Your ref: SSD7507

29 August 2016

**Re: Sydney Church of England Grammar School (Shore)
Physical Education Centre (SSD7507)
Blue & William Streets and Hunter Crescent, North Sydney**

Figure 5 – SPEC departure from the 12m height standard in elevation (Source: Cox Richardson, mark up of A-DA-0014)

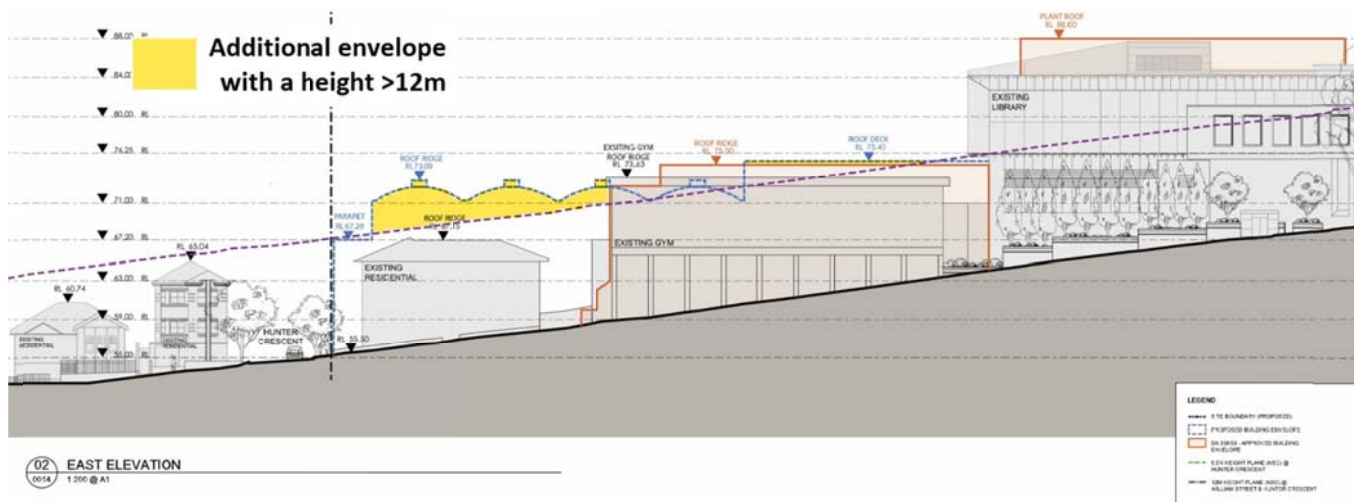
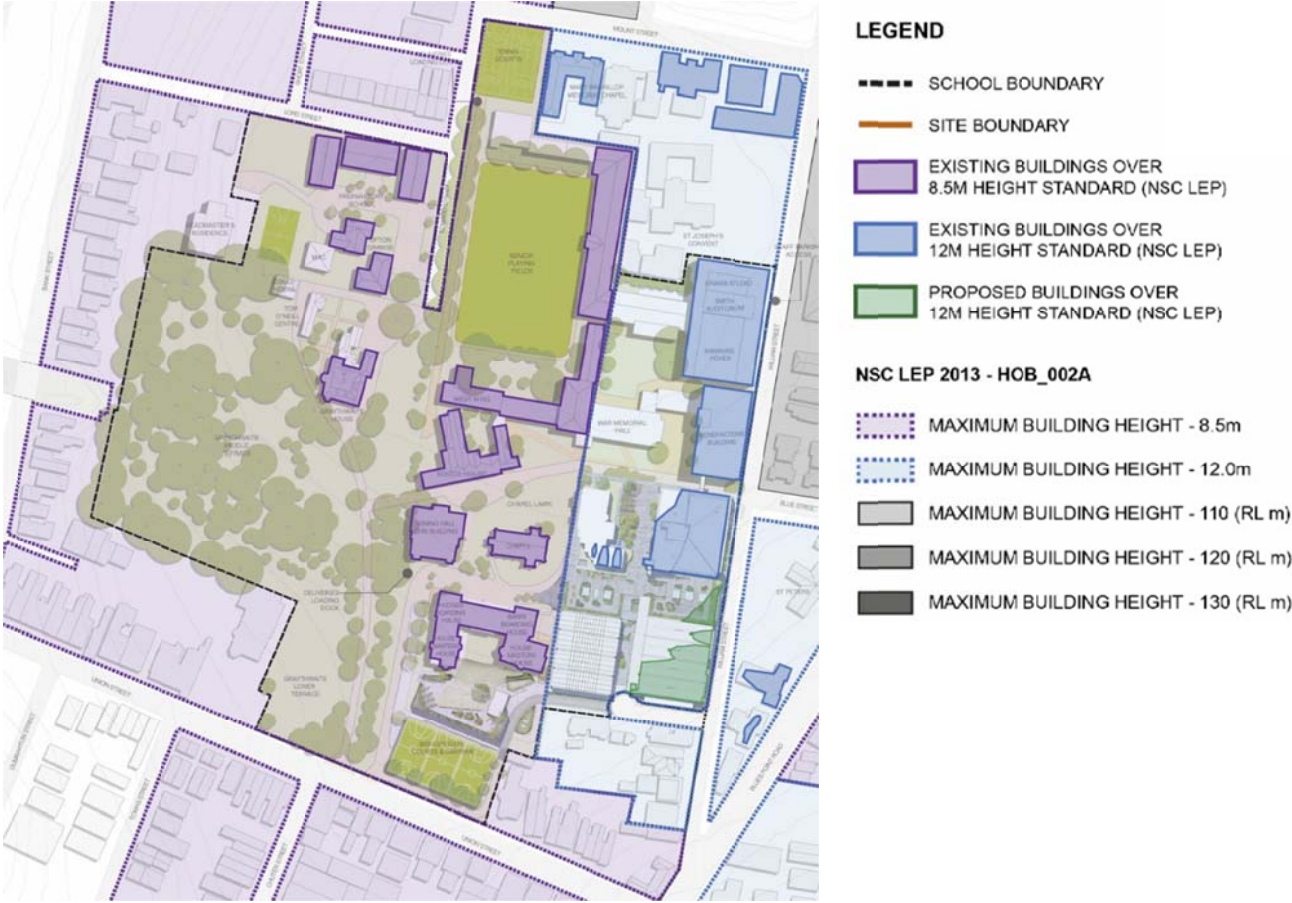
The consent authority should be satisfied that the proposed height non-compliance in relation to the multipurpose sports complex is acceptable with regard to the objectives of the control and the adequacy of the clause 4.6 request, in addition to giving detailed consideration to the amenity and other impacts of the proposed non-compliance.

Figure 4: Off-street parking area capacities before and after completion of SPEC

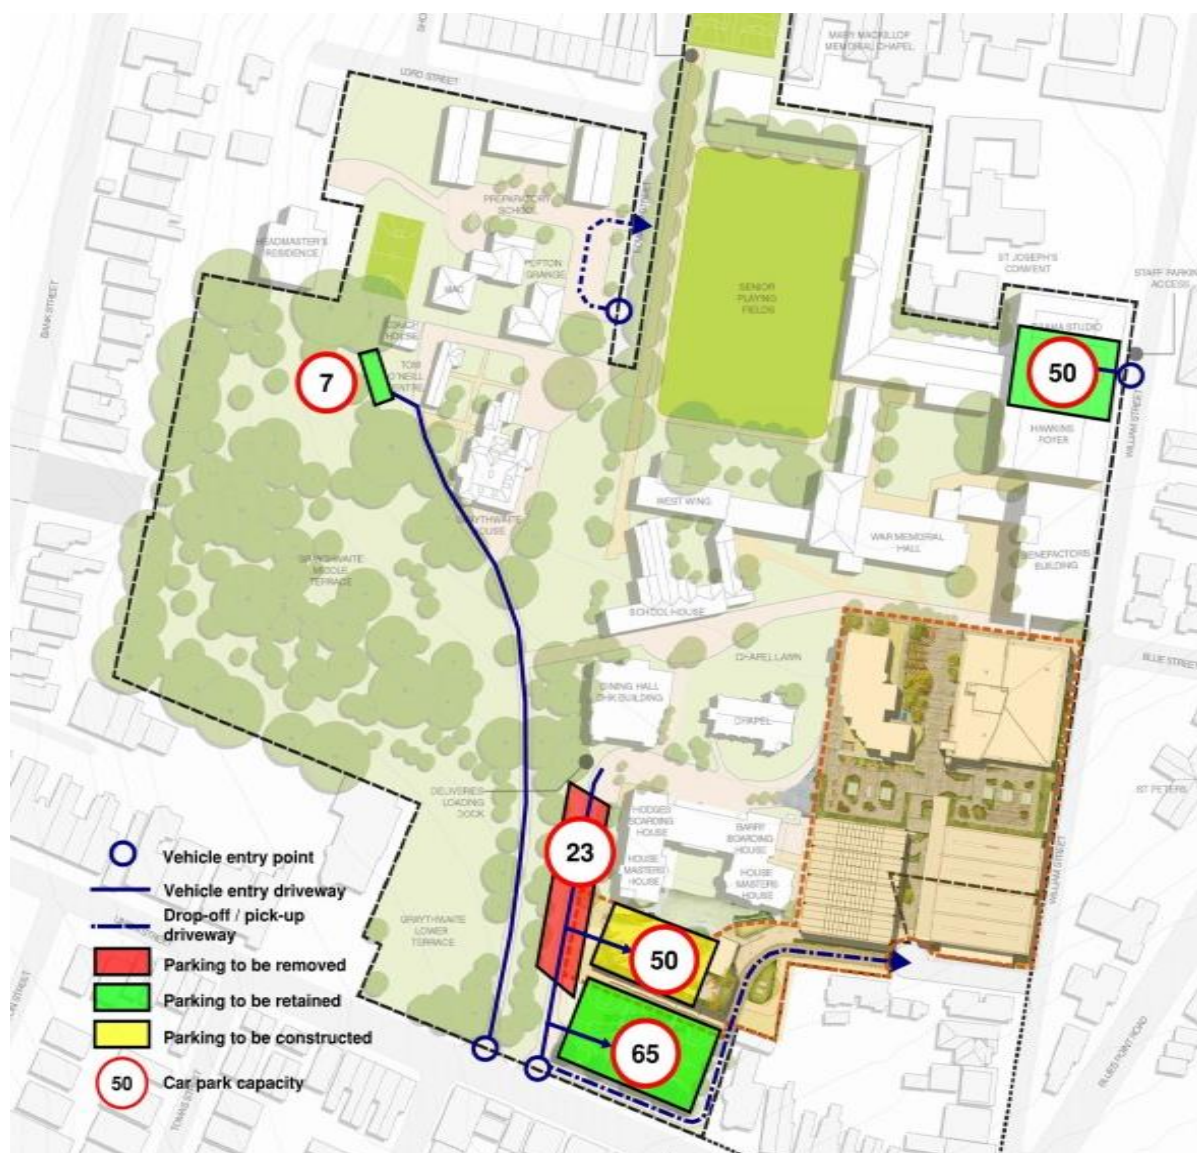
The existing parking provisions already significantly exceed the maximum requirements set out in the North Sydney DCP 2013 (269%). The development proposes an additional 38 parking spaces above the existing provision, which will further exceed the maximum requirements set out in the North Sydney DCP 2013. This is 338% of what is permitted under the DCP.

It is strongly recommended that the car parking provision be reduced to comply with the limits set out in North Sydney DCP 2013.

1. THAT there be no net increase in parking above existing levels (148 spaces)
2. THAT the School be required to review the operation of the existing drop-off and pick-up facility and include a reconfiguration of the drop-off and pick-up facility to ensure that all queuing occurs within the School site and not onto the public road, as part of the proposed development.
3. THAT the Shore School Transport Access Guide be reviewed to place more emphasis on alternatives to driving.
4. THAT a Demolition and Construction Management Program be prepared and submitted to Council for approval by the North Sydney Traffic Committee prior to the issue of a Construction Certificate. Any use of Council property shall require appropriate separate permits/ approvals.

BISHOP'S GATE CAR PARK &
RECONFIGURED DROP OFF/PICK-UP DESIGN

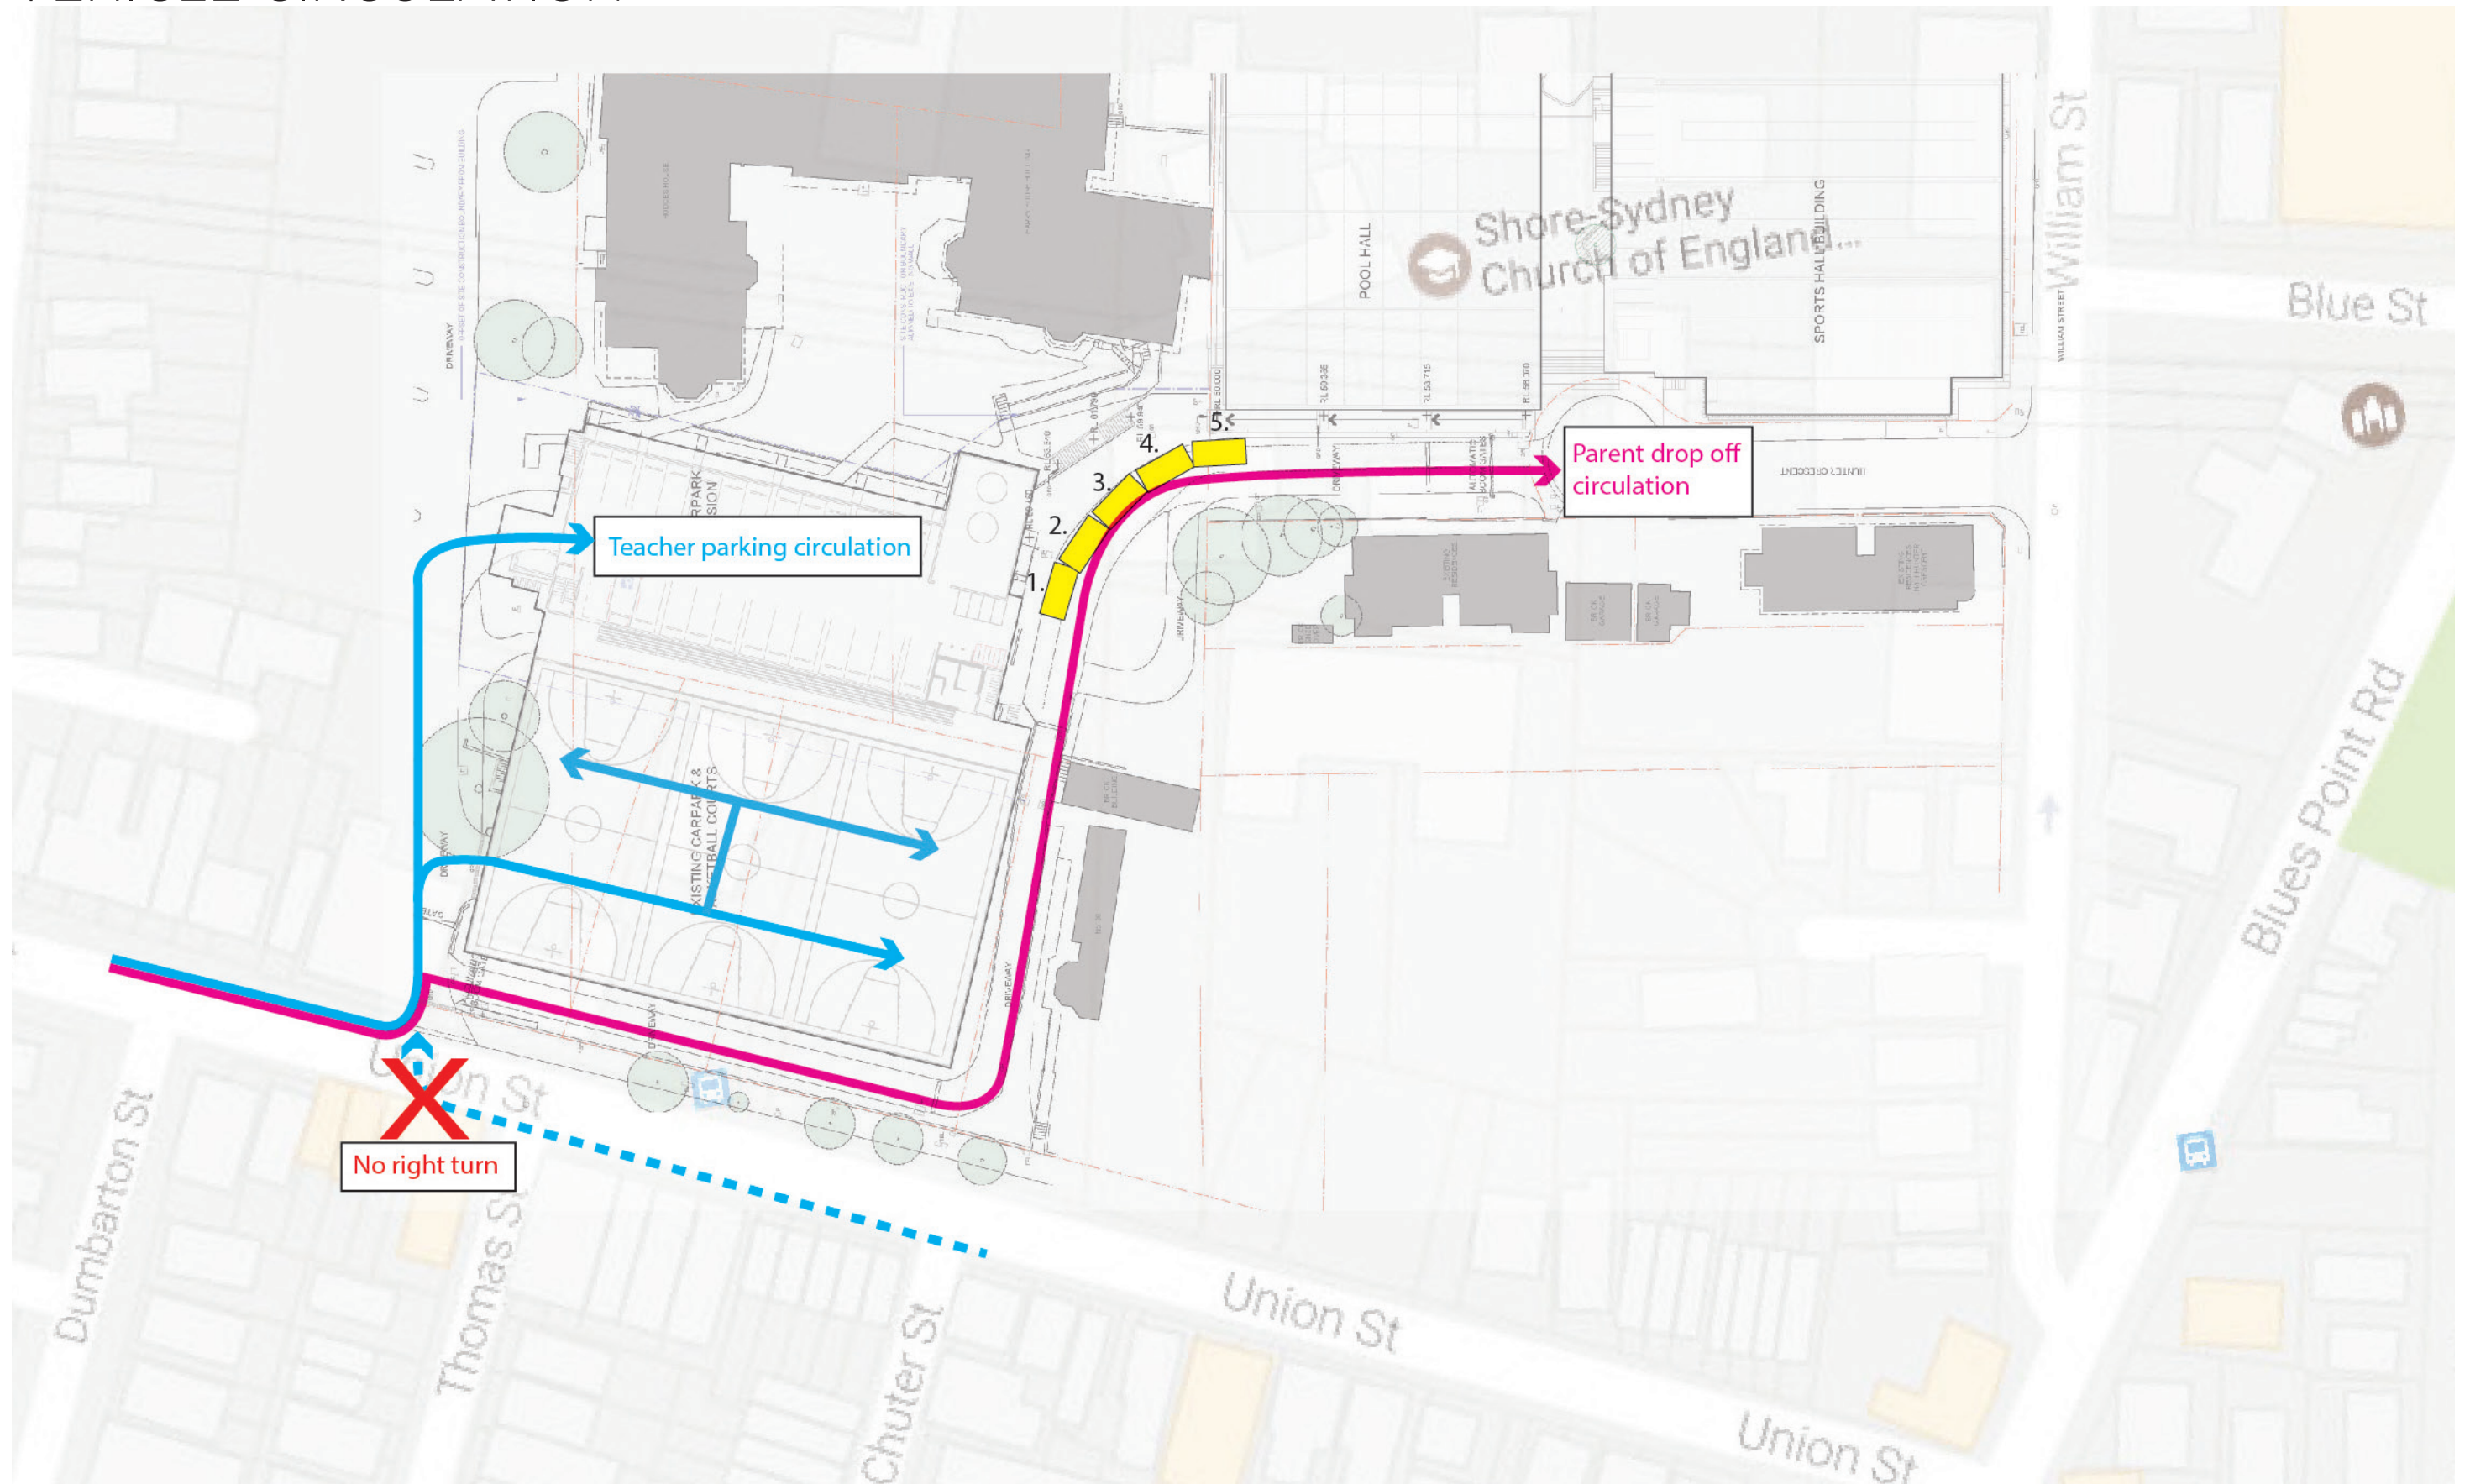
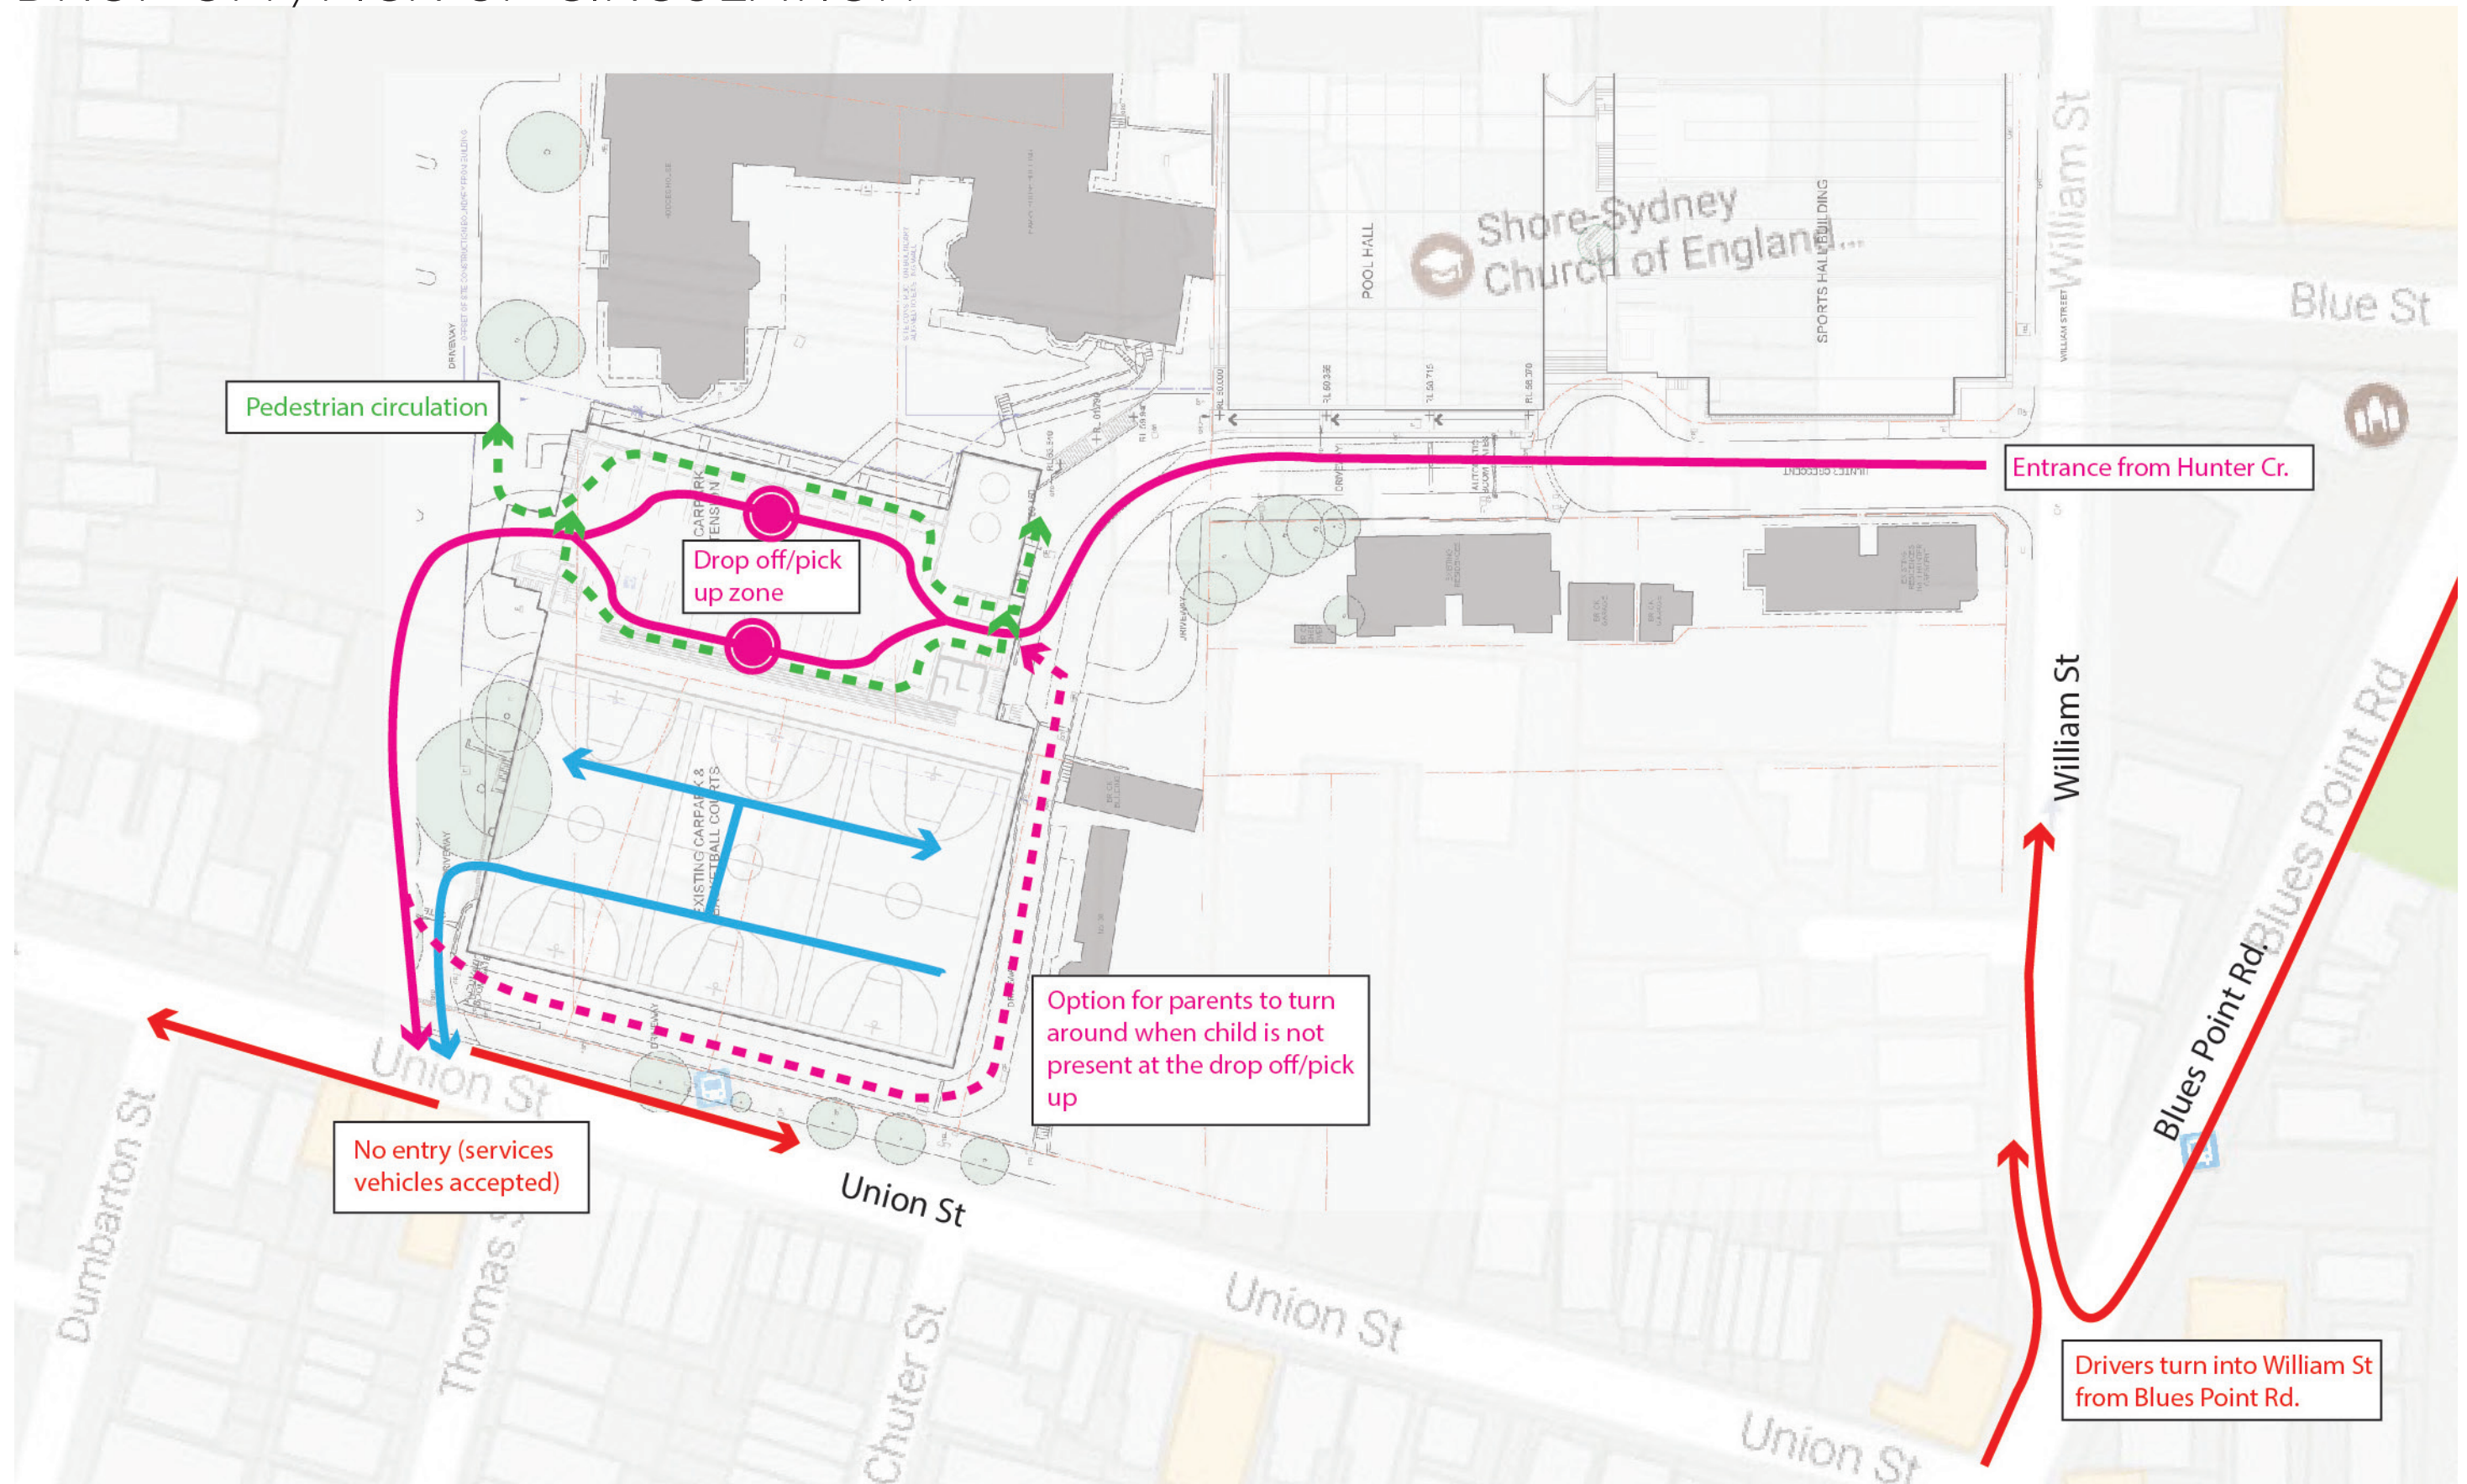
The Traffic Report does not assess the operation of the existing pick-up and drop-off facility. Inspections by Council staff have found that vehicles queue significantly onto Union Street during the afternoon pick-up. The internal pick-up queue exceeded the capacity with up to 9 vehicles queuing on Union Street. There are serious safety concerns with these operations as the queue blocks eastbound traffic on Union Street. East-bound vehicles were forced to overtake the queue of 9 vehicles on the wrong side of the road.

This operation should be reviewed as part of the proposed development and plans should include a reconfiguration of the drop-off and pick-up facility to ensure that all queuing occurs on site.
